Consultation Response from: KC Environmental Health (Pollution & Noise Control)

2018/92647 – Former Kirklees College, New North Road, Huddersfield HD1 5NN

Date Responded: 17 Feb 2021	Responding Officer: Richard Hume Rebecca Muff (Air Quality) Natalie Heaney (Contaminated Land)	Responding Ref: WK/202104614
---------------------------------------	---	--

1 FRONT ELEVATION
1 : 200

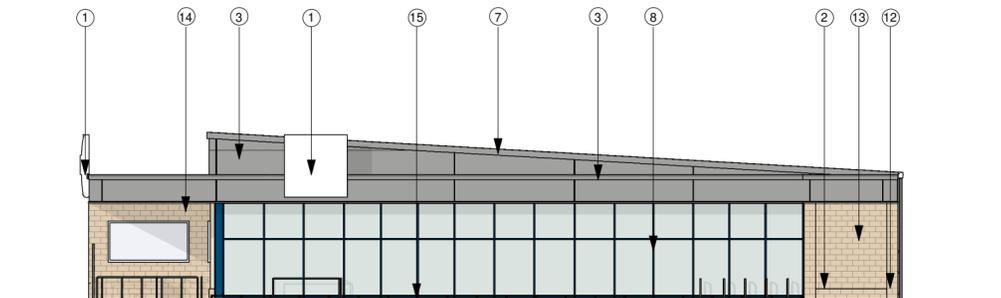
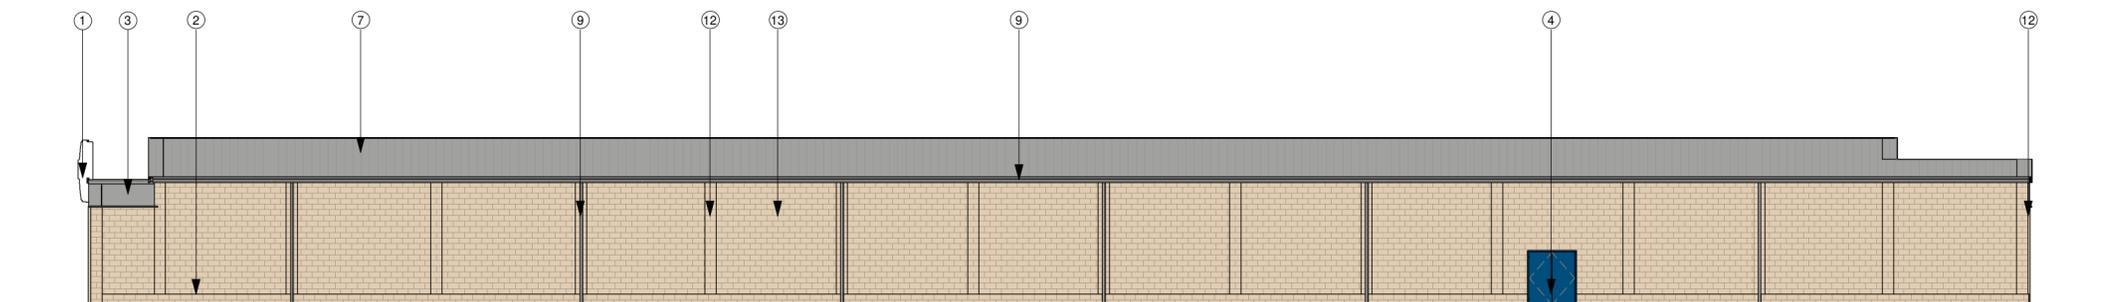
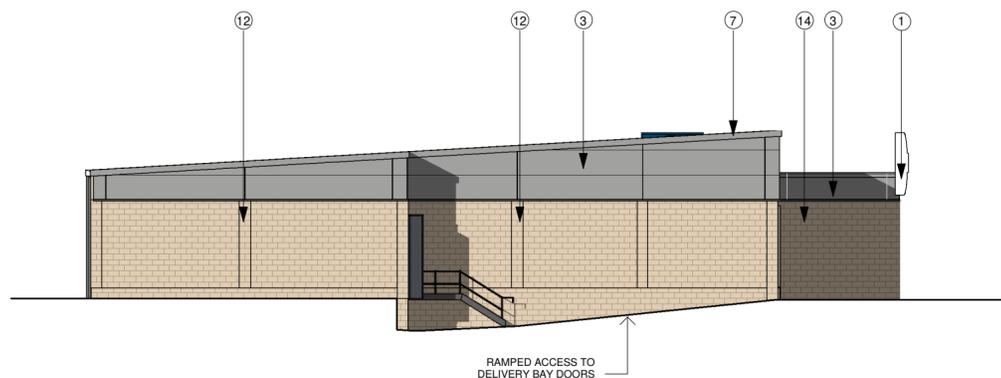
We have concerns that the proposed 5 storey buildings facing New North Road and Fitzwilliam Street will create a canyoning effect resulting in poor dispersion of pollutants. Currently this area is fairly open space, therefore we would expect the assessment to consider the impact that these tall buildings will have on the air pollution in that location and the sensitive receptors who will be residing in/near to them. The assessment should also include a revised cost damage calculation. In addition, we require details of any necessary air quality mitigation measures, including a suitable ventilation scheme, to protect any future residents from being exposed to high levels of pollution. Any air quality mitigation scheme should be compatible with any noise mitigation measures.

Therefore, a condition requiring an updated air quality impact assessment is necessary.
